Application Number: SSD-6693-Mod-1

OBJECTION: While we support renewable energy, we wish to OBJECT to the TRANSPORT ROUTE chosen for delivering equipment to the above applicant.

COMMENT on TRANSPORT ROUTE

C.5 OVER-DIMENSIONAL AND HEAVY VEHICLE ACCESS ROUTES

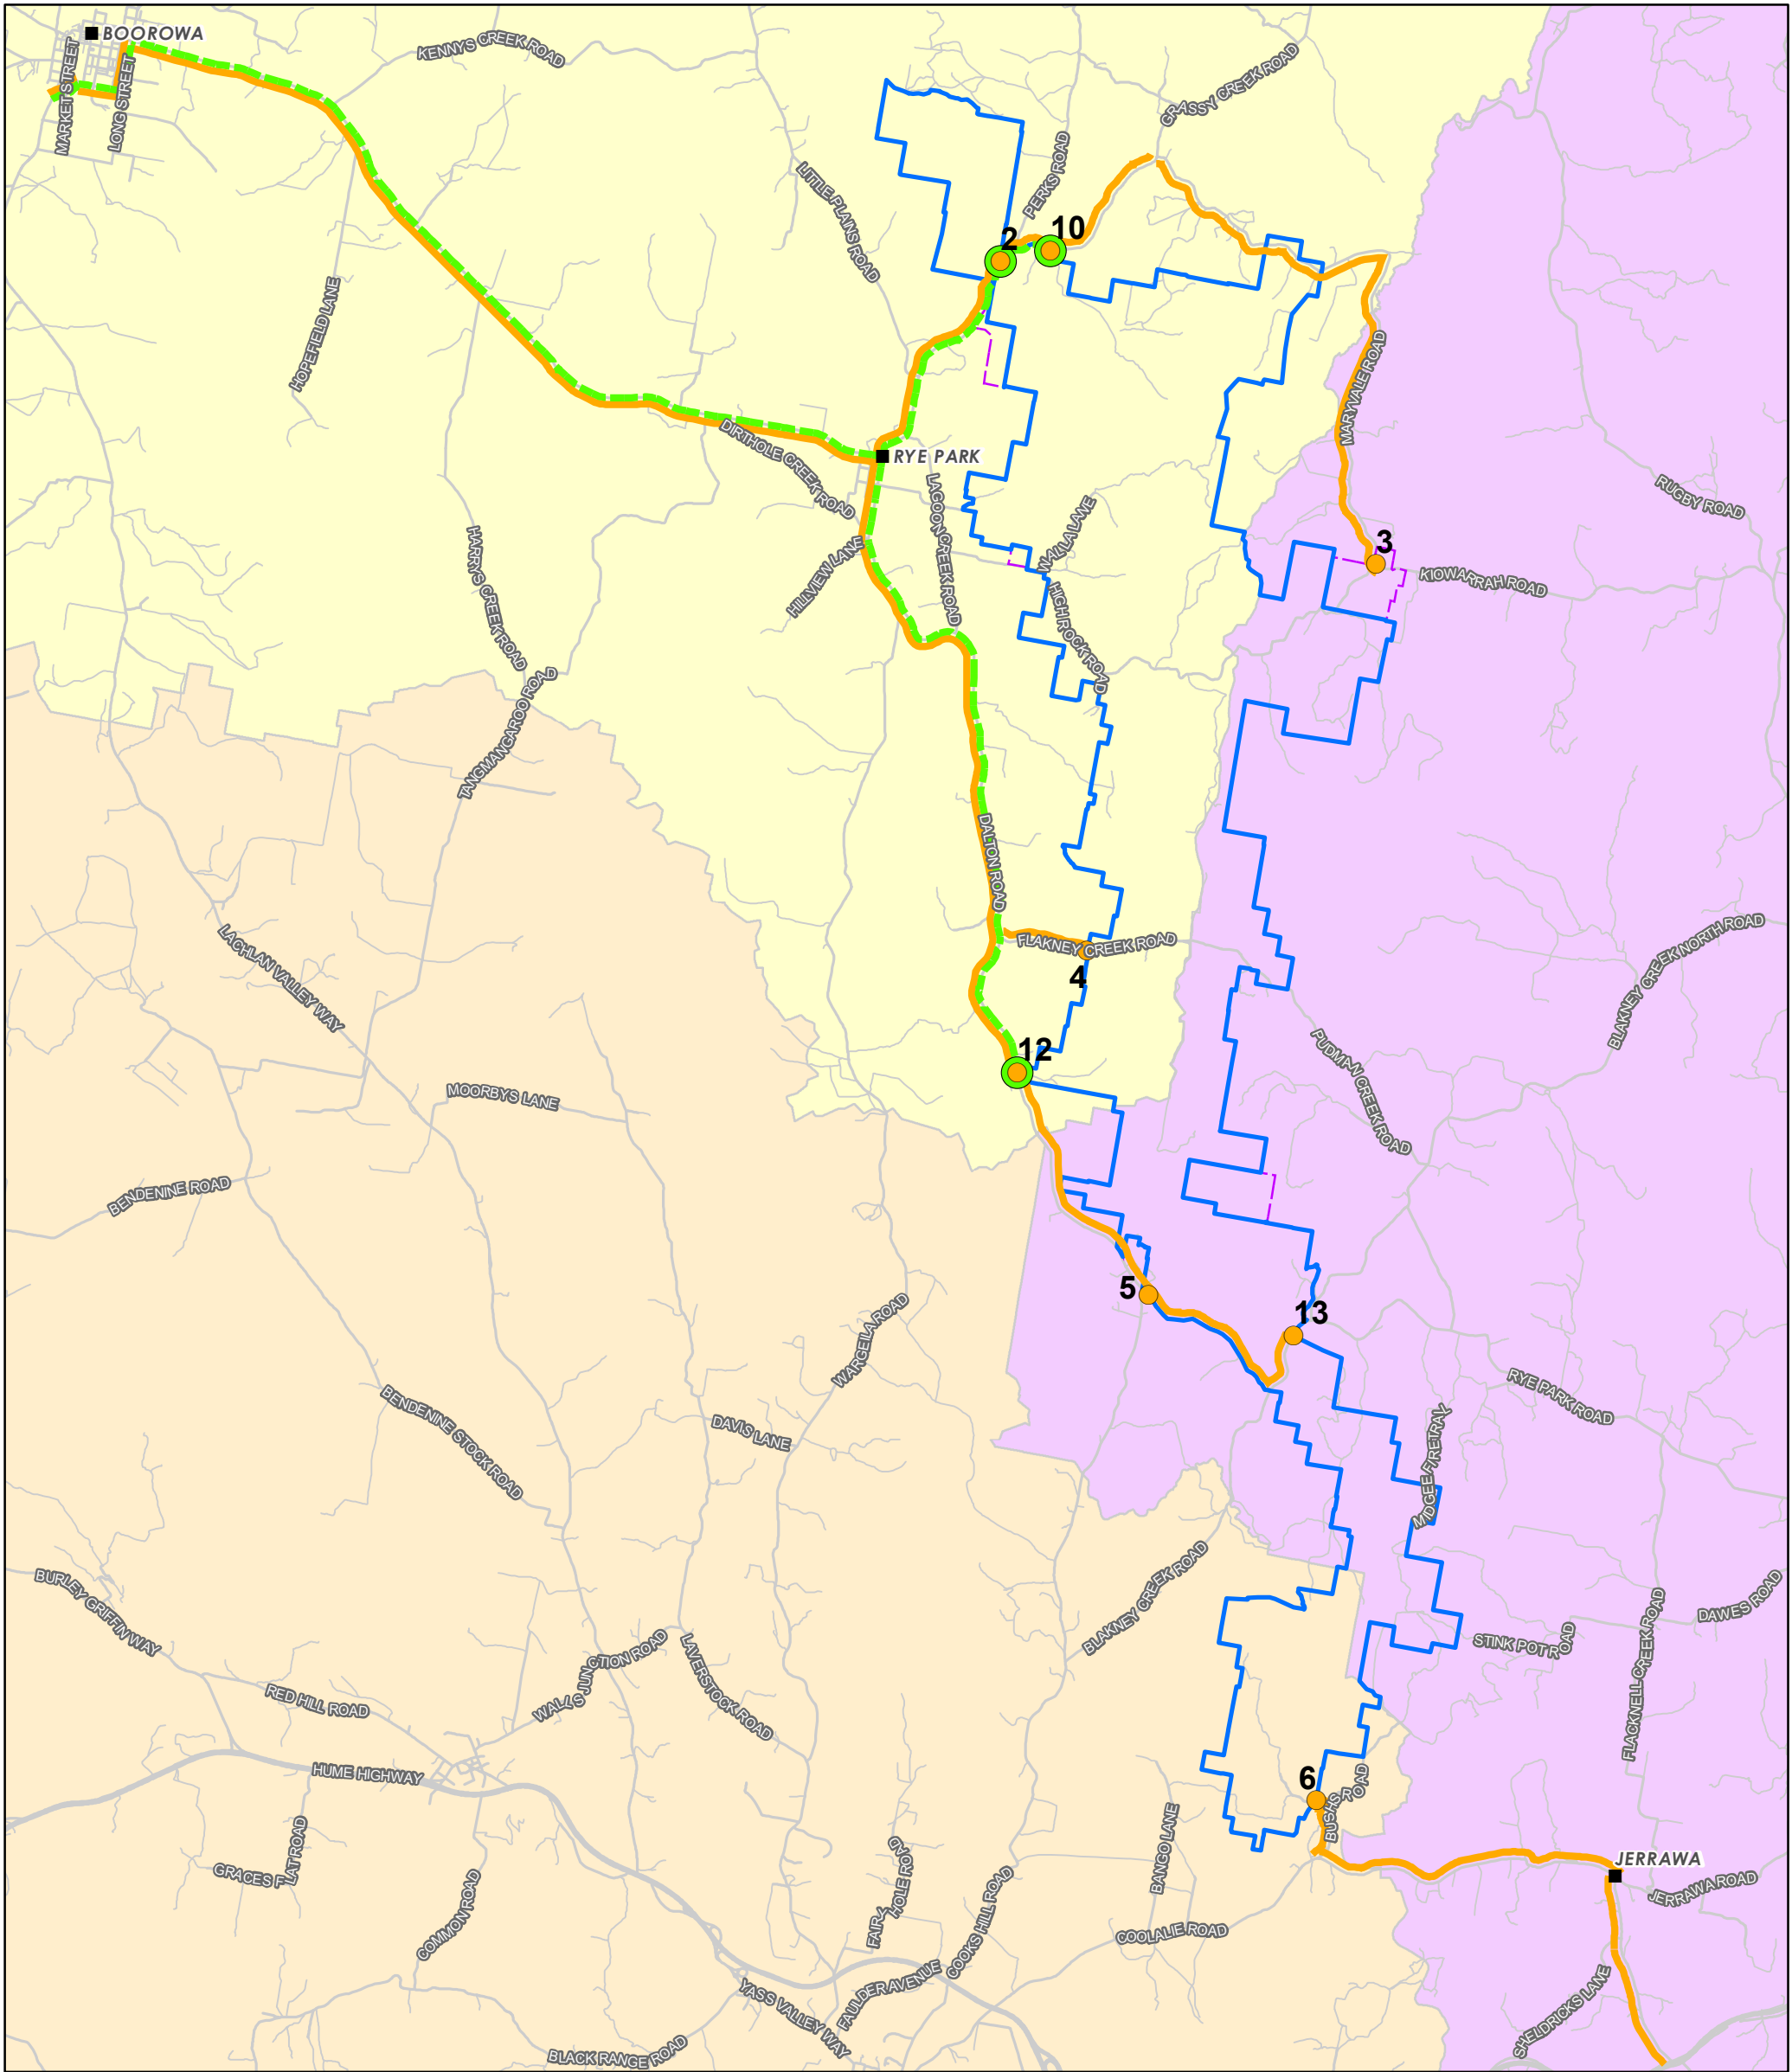
- The map indicated the company is extending its footprint on the corner of Dillon and Long Street onto our property. AT NO TIME HAVE WE BEEN APPROACHED BY SAID COMPANY TO USE OUR PROPERTY IN ANY WAY.

- The photo of our property is wildly out of date The Dillon Street frontage has 30+ trees and shrubs and extensive gardens. The photo shows a bare expanse of land. There is no indication of the gardens we have established in the area they wish to use. It is seen as vacant land. Our property is anything but! The photo does not show the trees, shrubs and gardens we have established in the past few years.

- We already suffer from severe runoff during storms and heavy rain. Extending the turning circle will ensure that water travels devastatingly through our property and the properties of our neighbours.

- We would suggest that the said company uses Mead's Lane and Long Street. This would be a route through farmland. It would require some amendment and improvement. However, it is a wide expanse of land whereby residential property would not be impacted upon. Mead's Lane is a right hand turn from Lachlan Valley Way the same as the turn into Trucking Yards Road.

- Mead's Lane is a straight road over one concrete culvert and the left turn onto Long Street would be via a flatter, barely used corner. After negotiating the bend, the journey down Long Street is straight with no turns. This is a more obvious route.
